From: Neville, Julie <Julie.Neville@lancashire.gov.uk>
Sent: 12 November 2024 18:05
To: Planning
Subject: 3/2024/0618 Bolton Fold Farm Alston Lane Longridge PR3 3BN
Attachments: 3 2024 0618 Overlay.pdf

Reference 3/2024/0618
Location Bolton Fold Farm Alston Lane Longridge PR3 3BN
Proposal Proposed change of use of a building and yard from agricultural to industrial storage and hardstanding. Replacement of existing walls and roof with new cladding and new roller shutter doors

Lancashire County Council Public Rights of Way Team is not supportive of the plans / raises no objection /objects to the application and provides the following.

**Drawing Title**  
 PROPOSED SITE PLAN

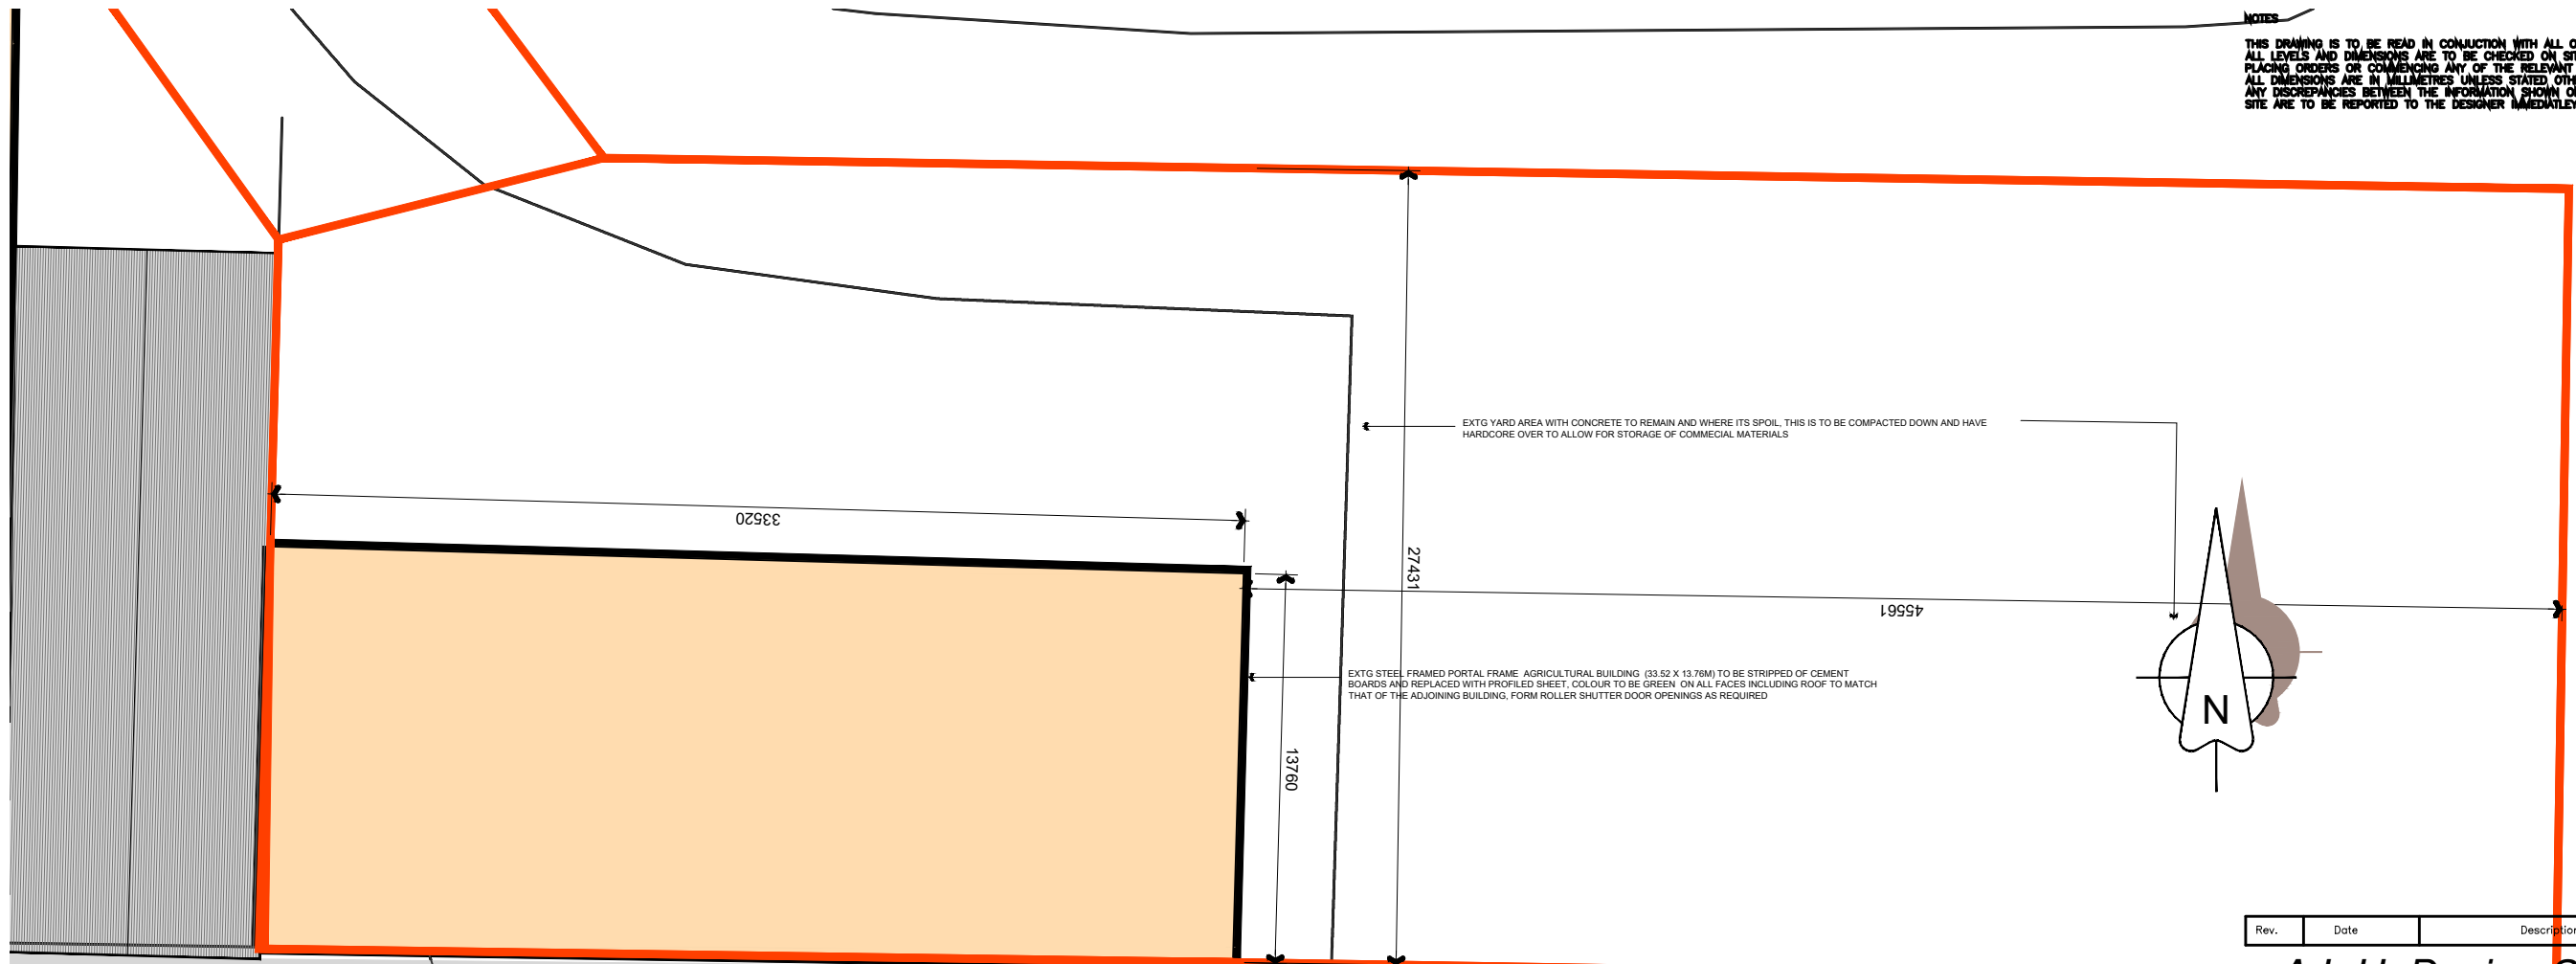
Footpath FP0302069 is recorded along the southern boundary of the application, as shown on the attached plan. The plan also highlights the obstruction of the footpath from supplemental buildings erected over the right of way, which is a criminal offence and something that would impact the sale and potential value of the holding. This being so, the proprietors obstructing the right of way may wish to consider pursuing a Public Path Order under the provisions of Highways Act 1980 Section 119, administered by Lancashire County Council. An application to divert a public right of way under Section 119 of the Highways Act 1980 can be made by emailing the Public Path Orders Officer adrian.ibison@lancashire.gov.uk

The infringement or obstruction of the existing public rights would be a criminal offence, as such the right of way should always remain clear, not to be excavated nor used to park or store materials, vehicles or machinery.

Any changes in ground level or installation of drainage should ensure that surface water is not discharged onto a public right of way either within the proposed development site or in close proximity – this is to ensure public rights of way are not exposed to potential flooding or future maintenance issues.
